Our ref: **SHARE 20040073**
Your ref: **TR050007**

Planning Inspectorate

APPLICATION BY TRITAX SYMMETRY (HINCKLEY) LIMITED (“THE APPLICANT”) SEEKING DEVELOPMENT CONSENT FOR THE PROPOSED HINCKLEY NATIONAL RAIL FREIGHT INTERCHANGE PROJECT (“THE PROPOSED DEVELOPMENT”)

This submission forms National Highways’ response following a review of the additional information provided by the Applicant to Secretary of State on 10 December 2024.

GIBBET LANE NB  
(HGV)

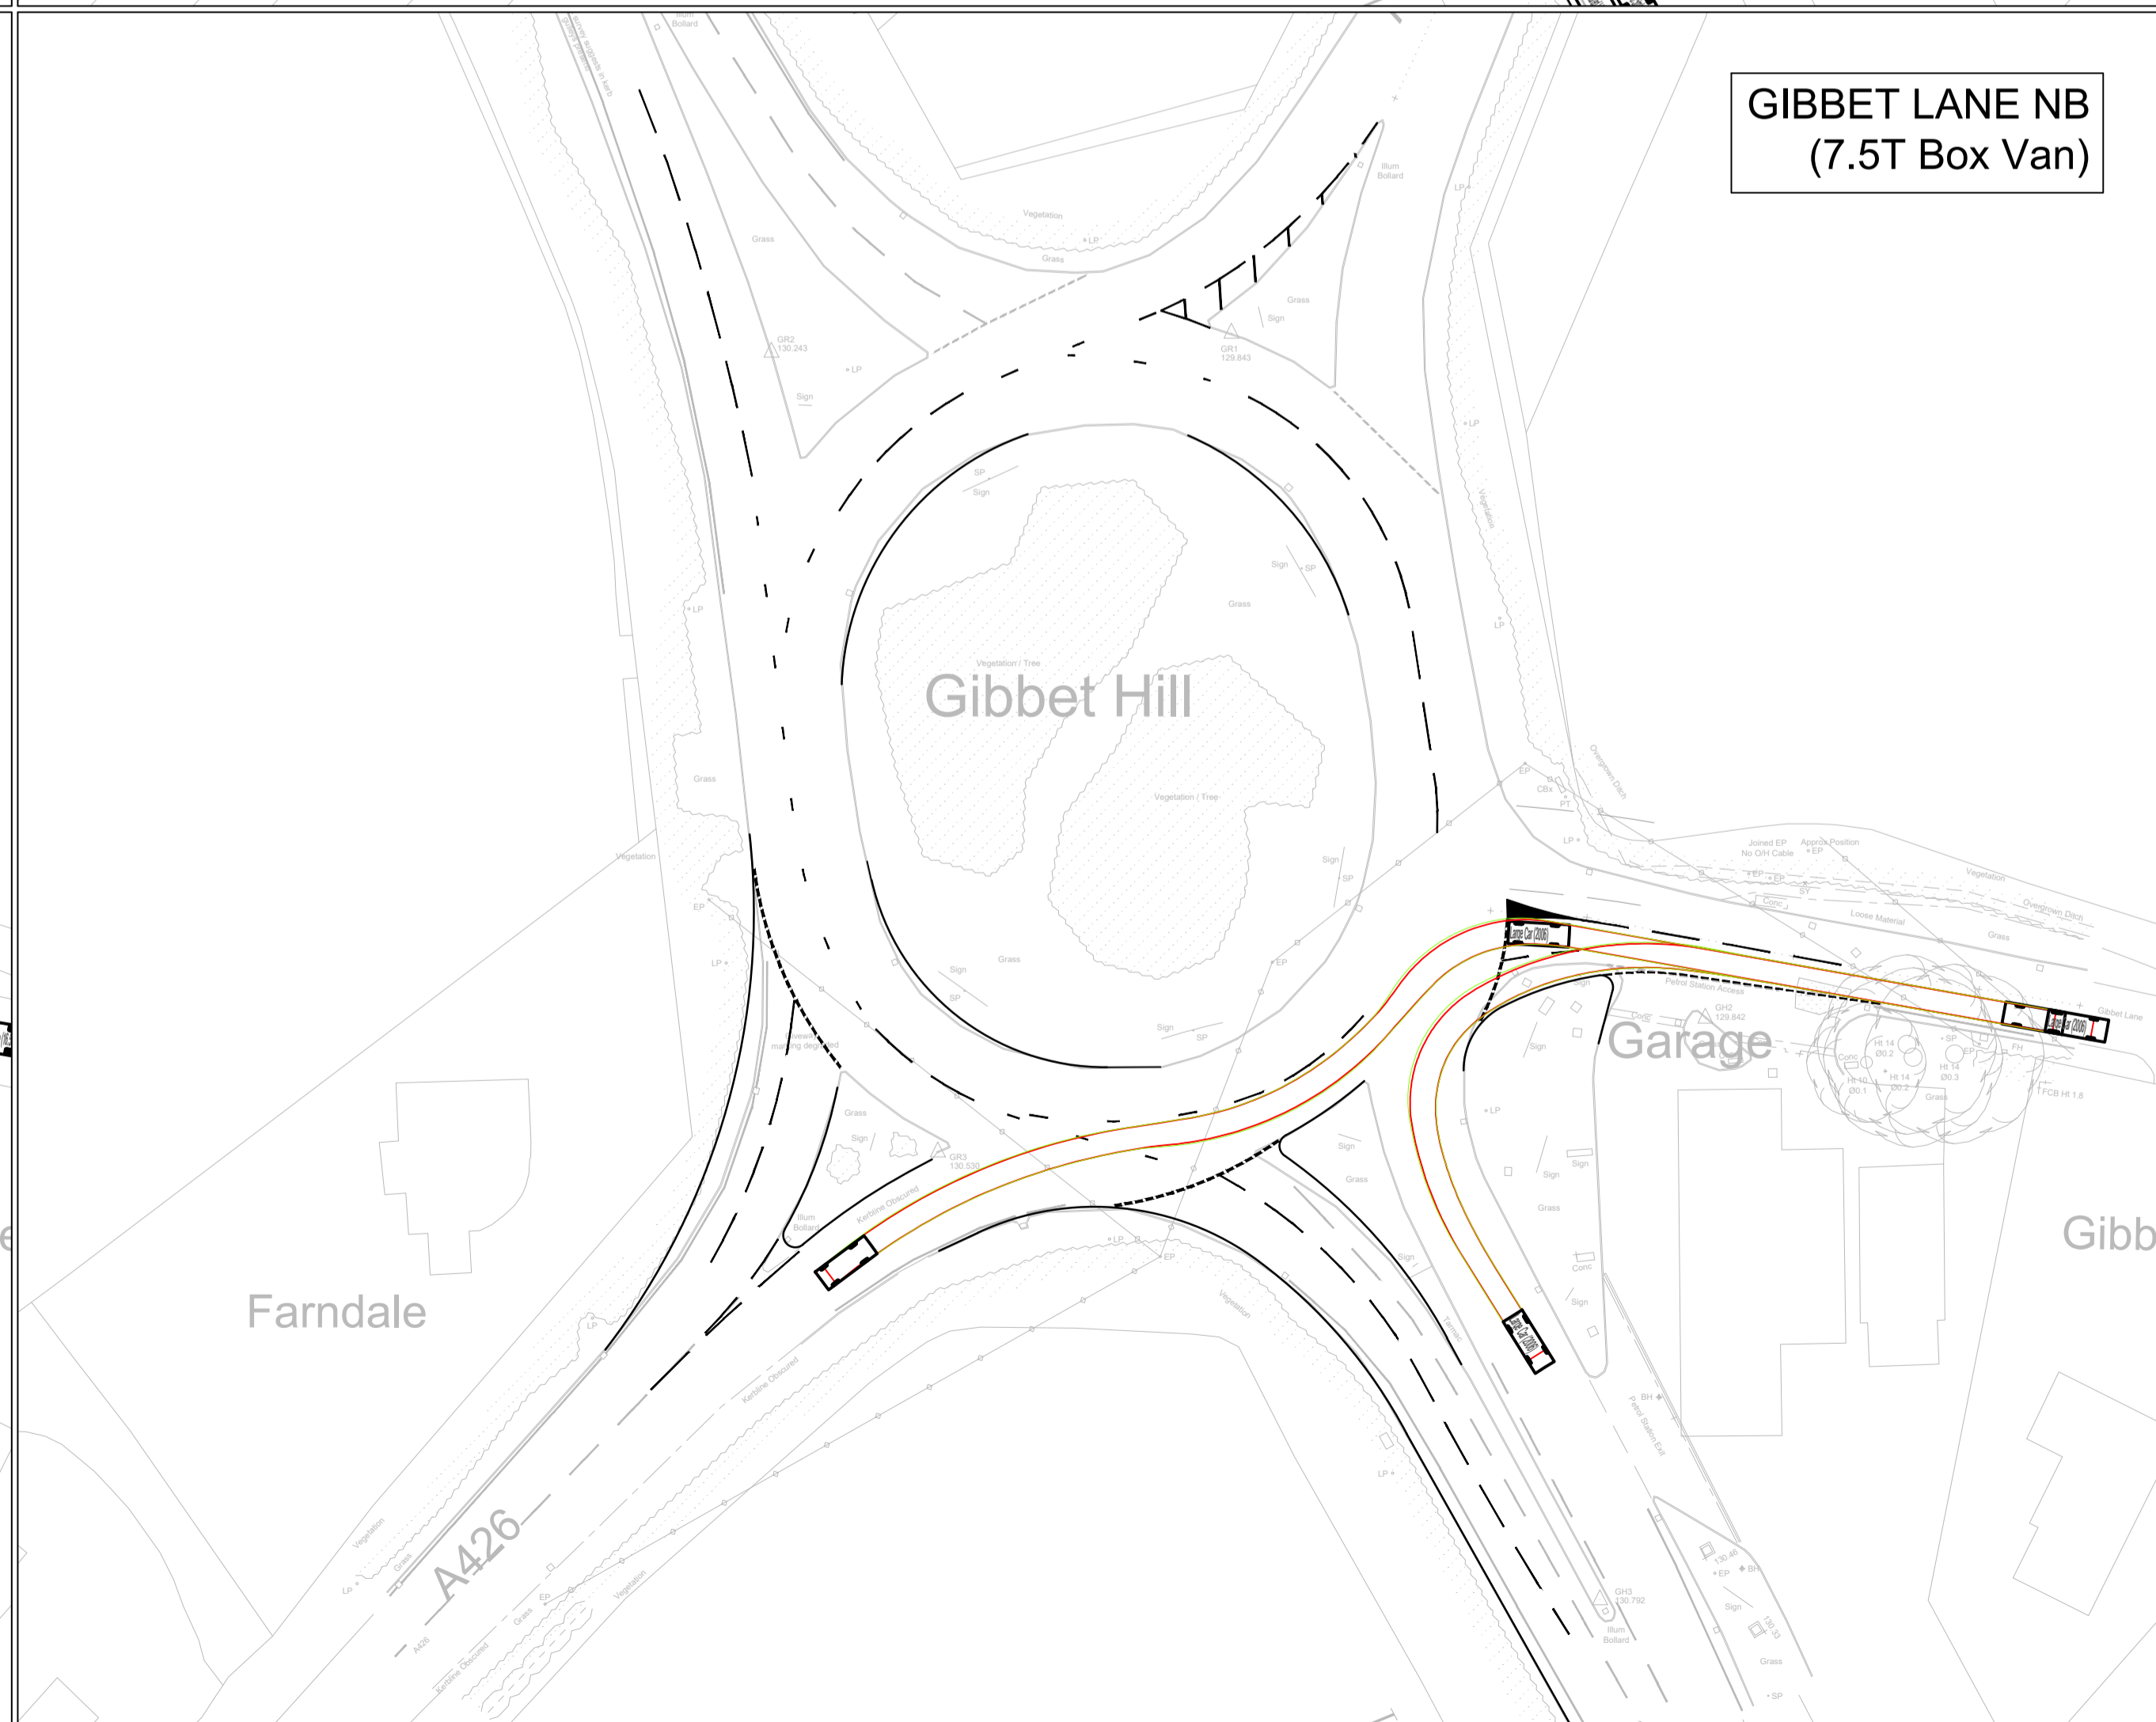
Considering the proposed mitigation scheme is meant to enable two HGV's to route side-by-side around the circulatory, we remain concerned that it has not been suitably demonstrated that this can be safely accommodated. The Applicant has submitted a swept path analysis showing how vehicles shall track the circulatory, however this does not demonstrate sufficient clearance to address this concern.

Should HGV drivers consider this side-by-side manoeuvre unsafe, this results in effectively only one of the two lanes at the A5 south approach being available to HGVs. As the Junctions 10 model assumes HGVs can use both lanes, the model results in this case would underestimate the suitability of the proposed scheme to mitigate the development's traffic impacts at this A5 approach.
